CITY OF ALBUQUERQUE

December 5, 2011

**Re: Car Crafters – Automotive Repair Garage, 5404 Edith Blvd NE,
Traffic Circulation Layout
Architect's Stamp dated 10-20-11 (F15-D036)**

CIRCULATION

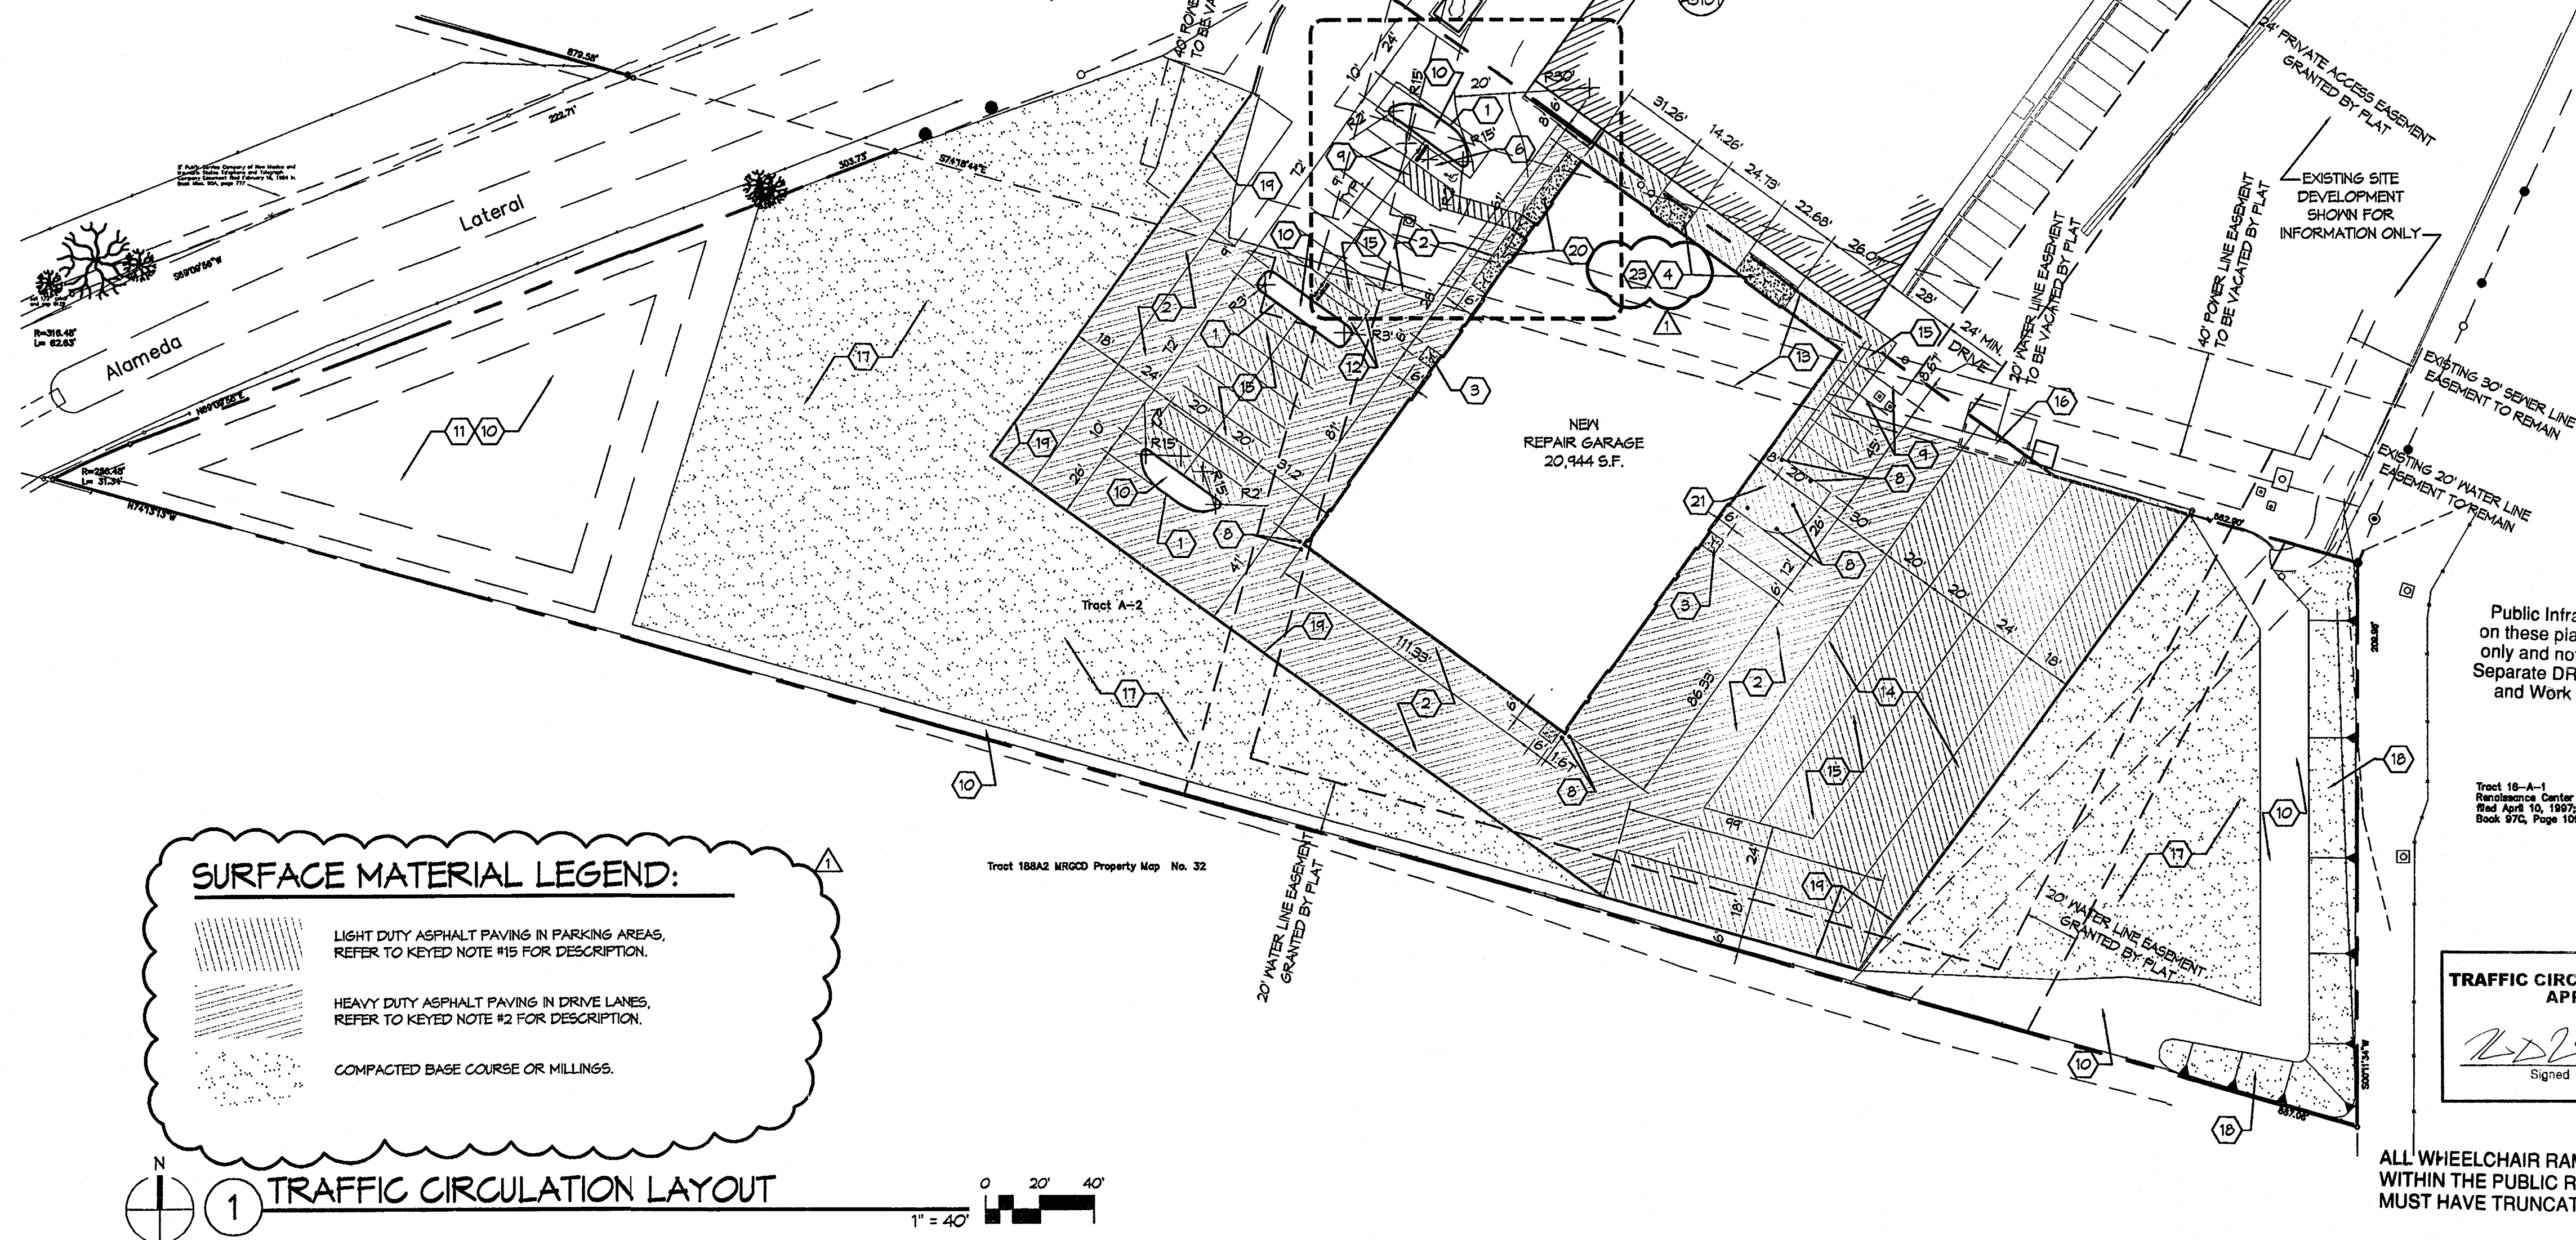
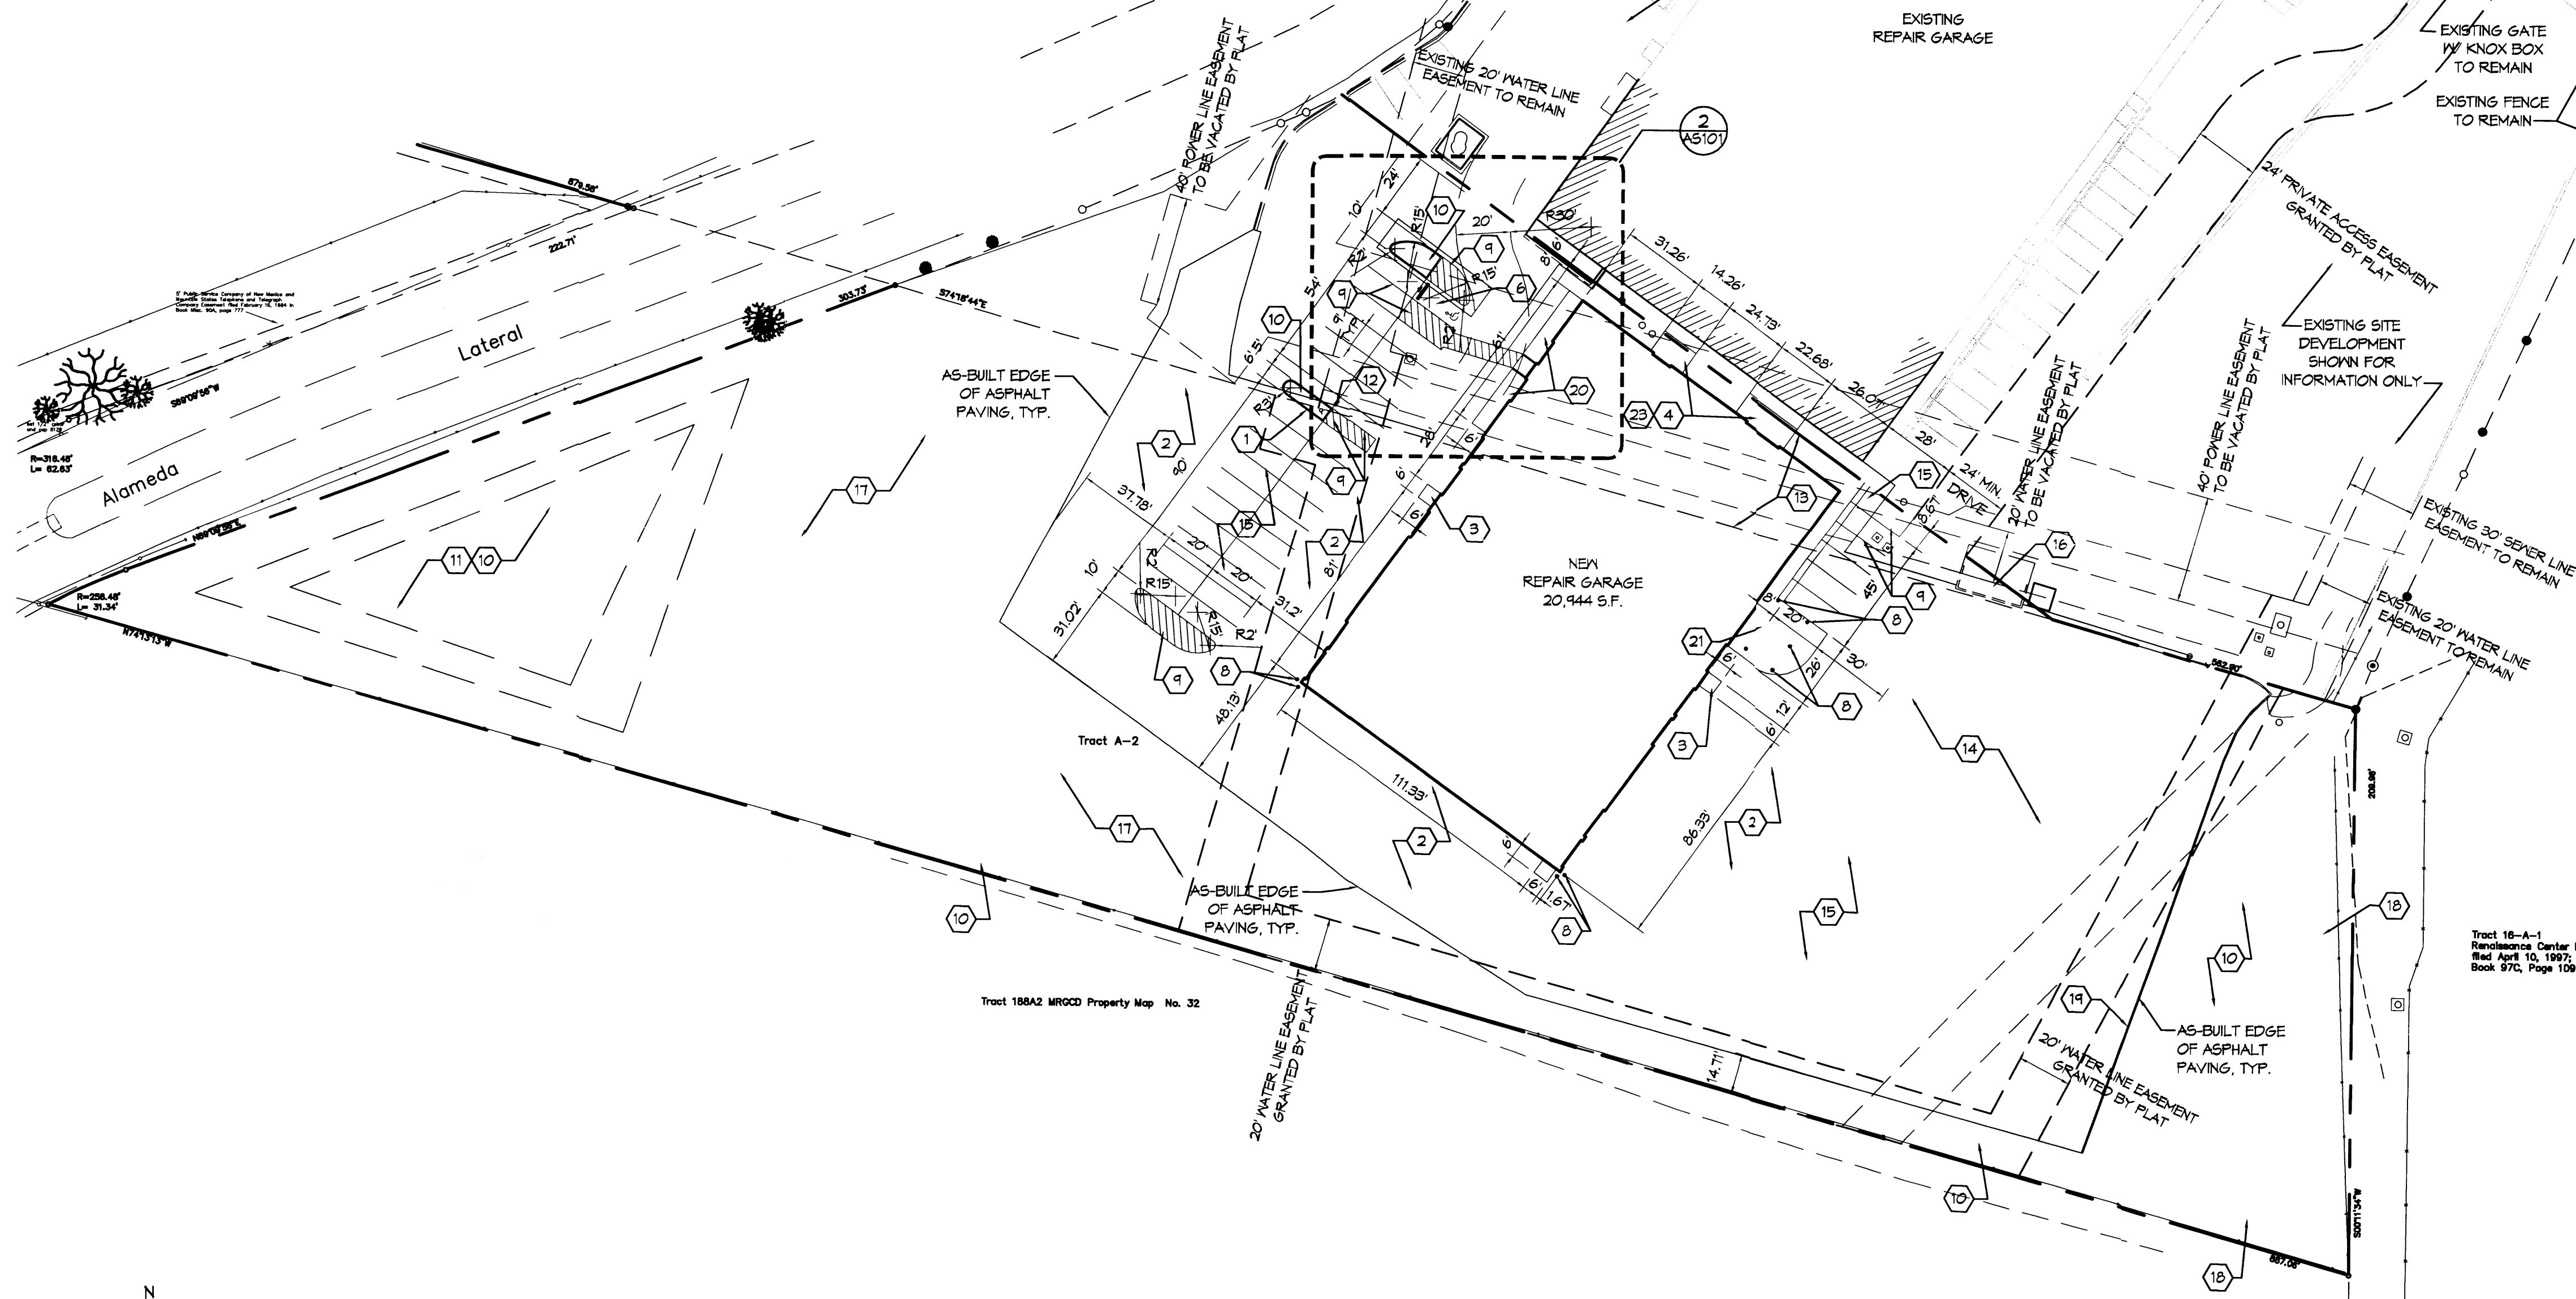
1. Please clarify the status of the proposed platting action. What is the DRB project number? An approved preliminary plat must be provided prior to building permit approval.

2. Clarify how the proposed access easement will function with the existing Knox box shown on site. This information must be provided on the plan.
3. The site layout indicates access will be shared at the northeast and northwest corners of the site. However, an access easement is shown only in the northeast corner of the site. Please revise.

4. Provide a legend identifying all hatching and linetypes.
5. Parking spaces cannot cross the lot lines.
6. The proposed concrete walkway cannot be flush with the asphalt, as this places it directly within the vehicular way.

7. Clearly indicate the 6-foot wide, ADA accessible pathway from the handicapped parking stalls to the building.
8. Clearly indicate the 6-foot wide, ADA accessible pathway from the roadway to the building.

9. Define the width of all parking stalls.
